Addendum No. 1

RE: Contract # C204737

Moore County (U-5815BA)

SR-2055 (N POPLAR ST) FROM ELM ST IN ABERDEEN TO 500' NORTH OF BLUES CROSSING LN IN SOUTHERN PINES

PROJECT REFERENCE NO.	SHEET NO.
U-5815BA	UC-11
DESIGNED BY: NLH	
DRAWN BY: JNB	
CHECKED BY: CPM	
APPROVED BY: NLH	
REVISED:	
NORTH CAROLINA DEPARTMENT OF TRANSPORTATION	
UTILITIES ENGINEERING SEC. PHONE: (919) 707-6690 FAX: (919) 250-4151

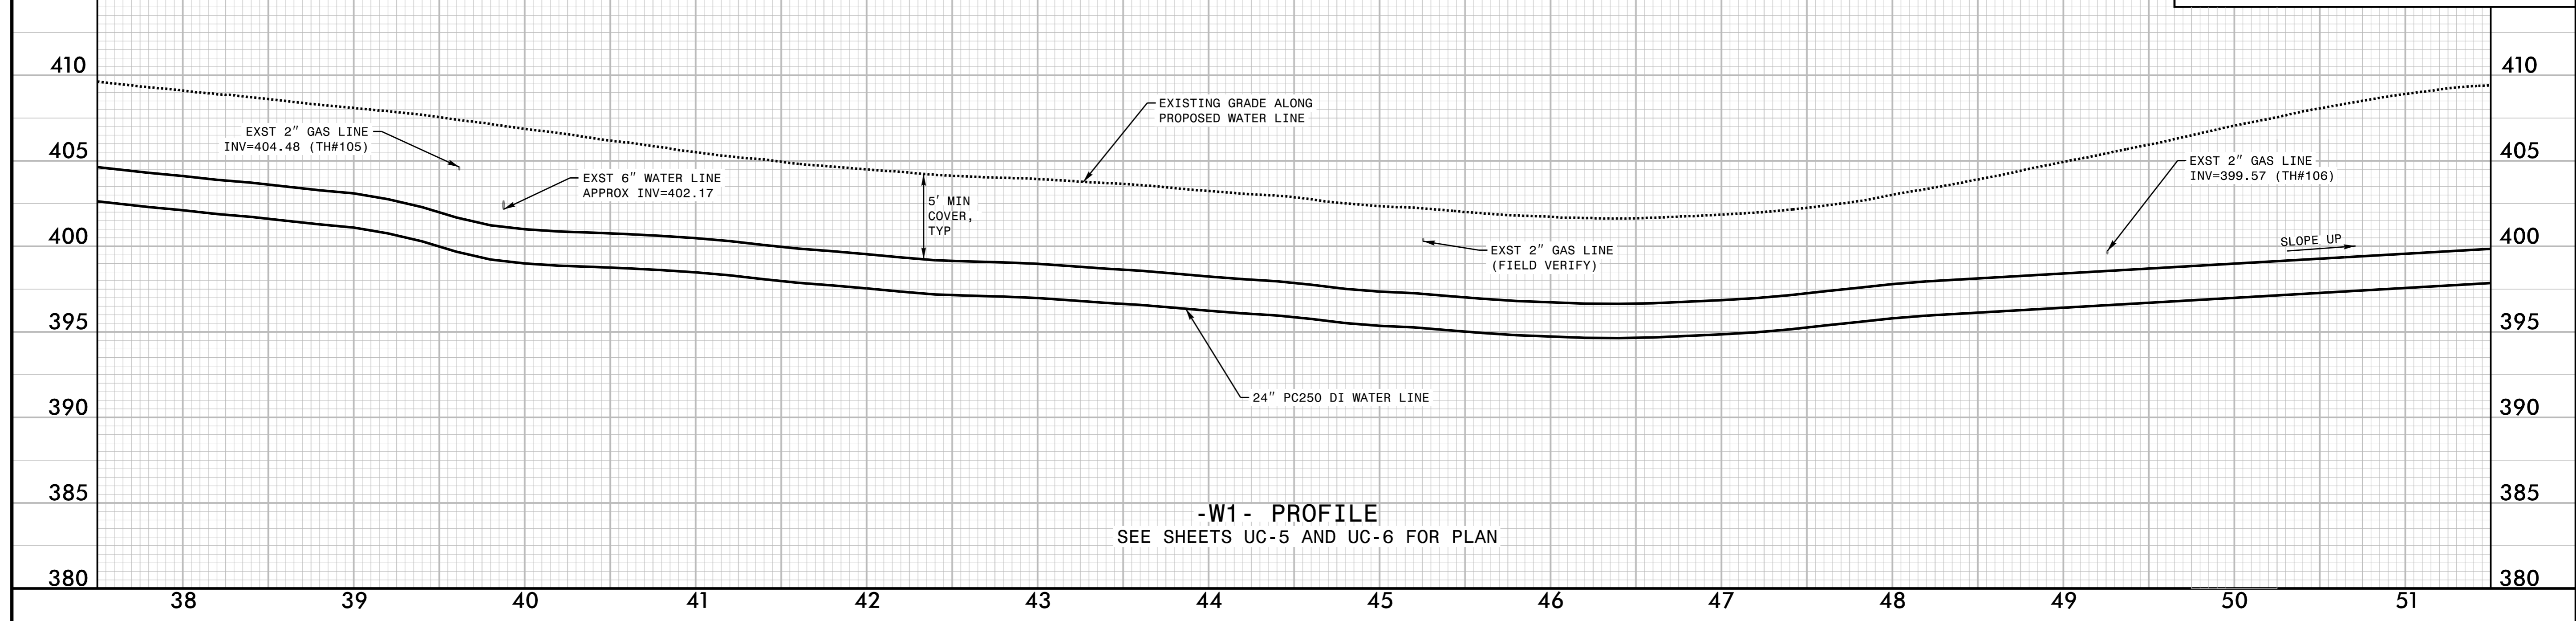
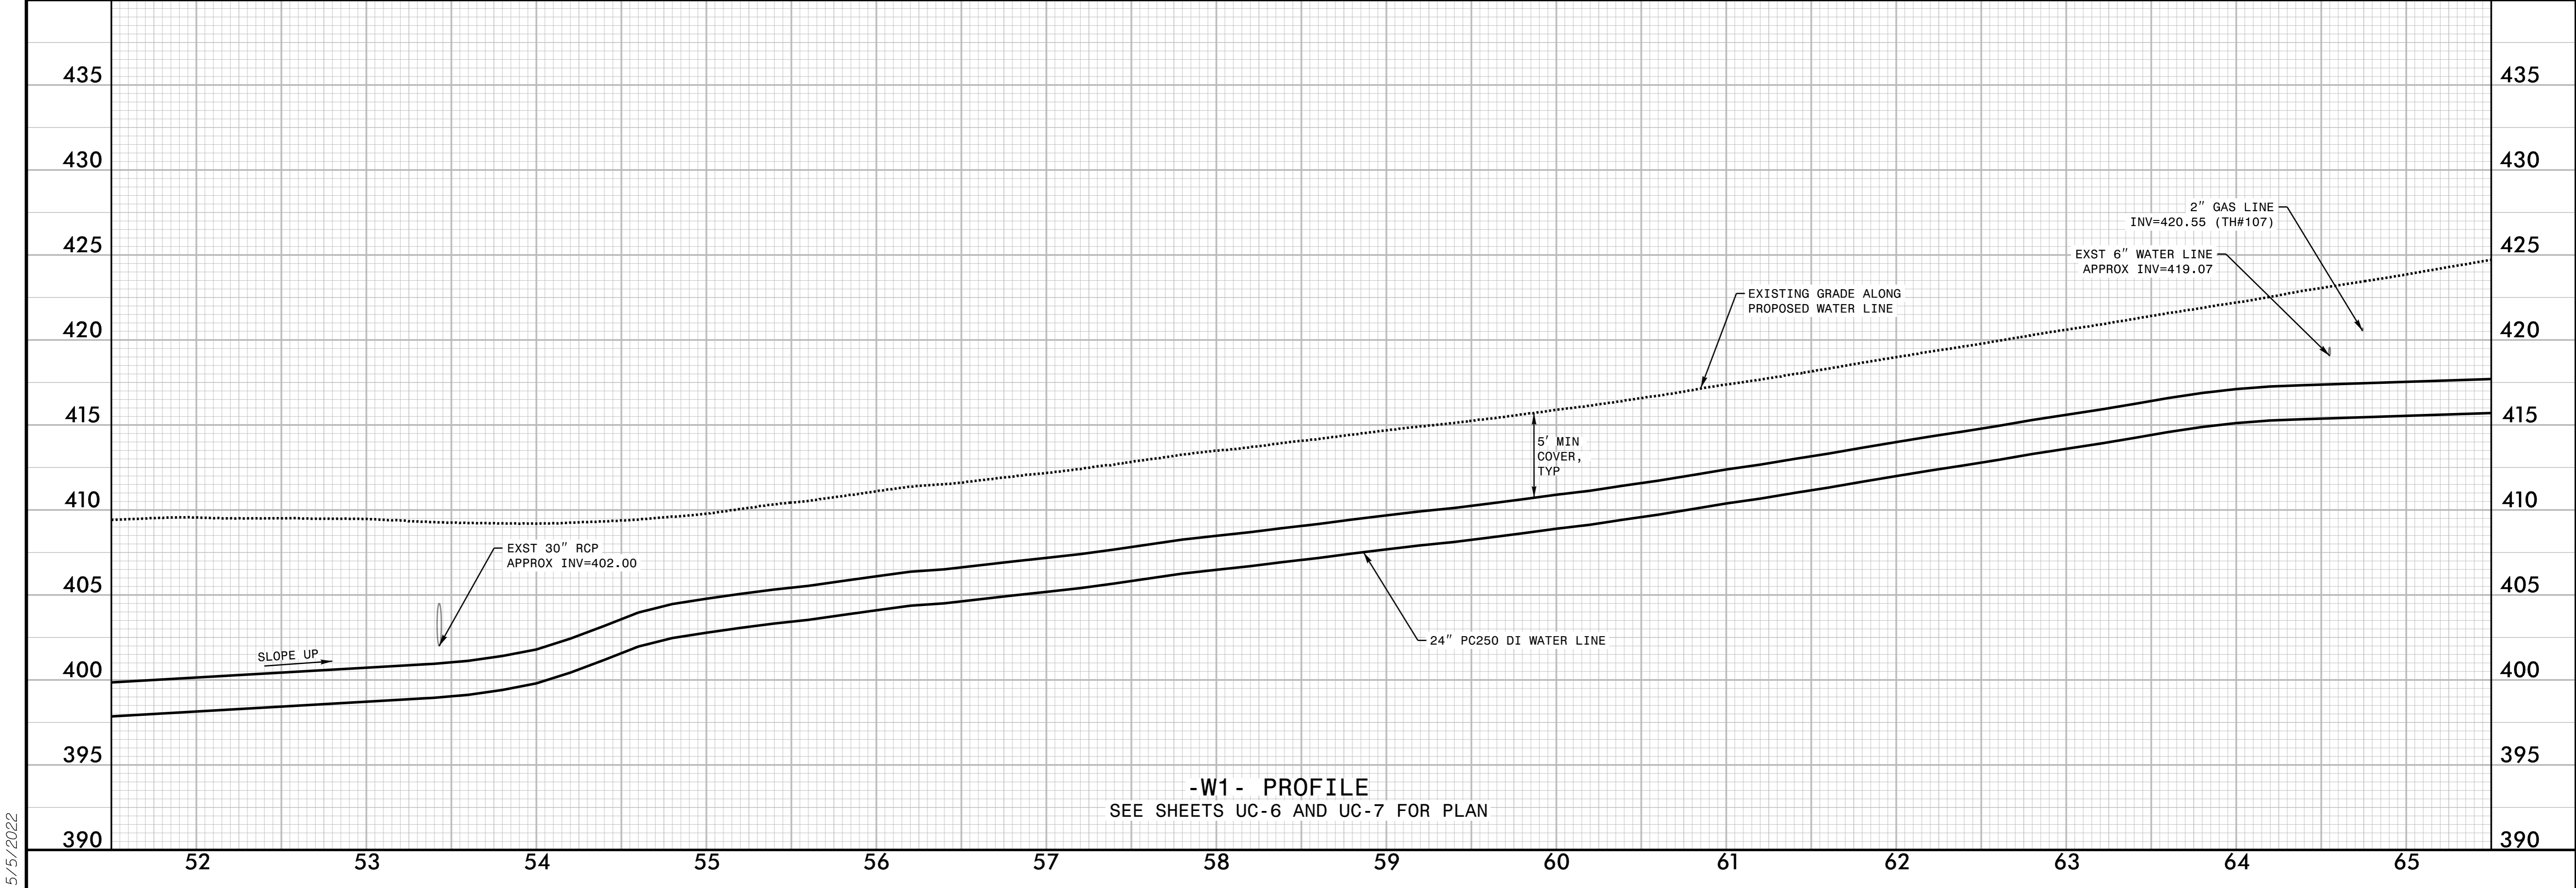
Sheet No.	Revision
UC-10 to UC-13	Revised vertical location of crossing gas lines shown on water line profiles based on test holes. Minor vertical adjustments to water line profiles to avoid conflicts with gas lines.
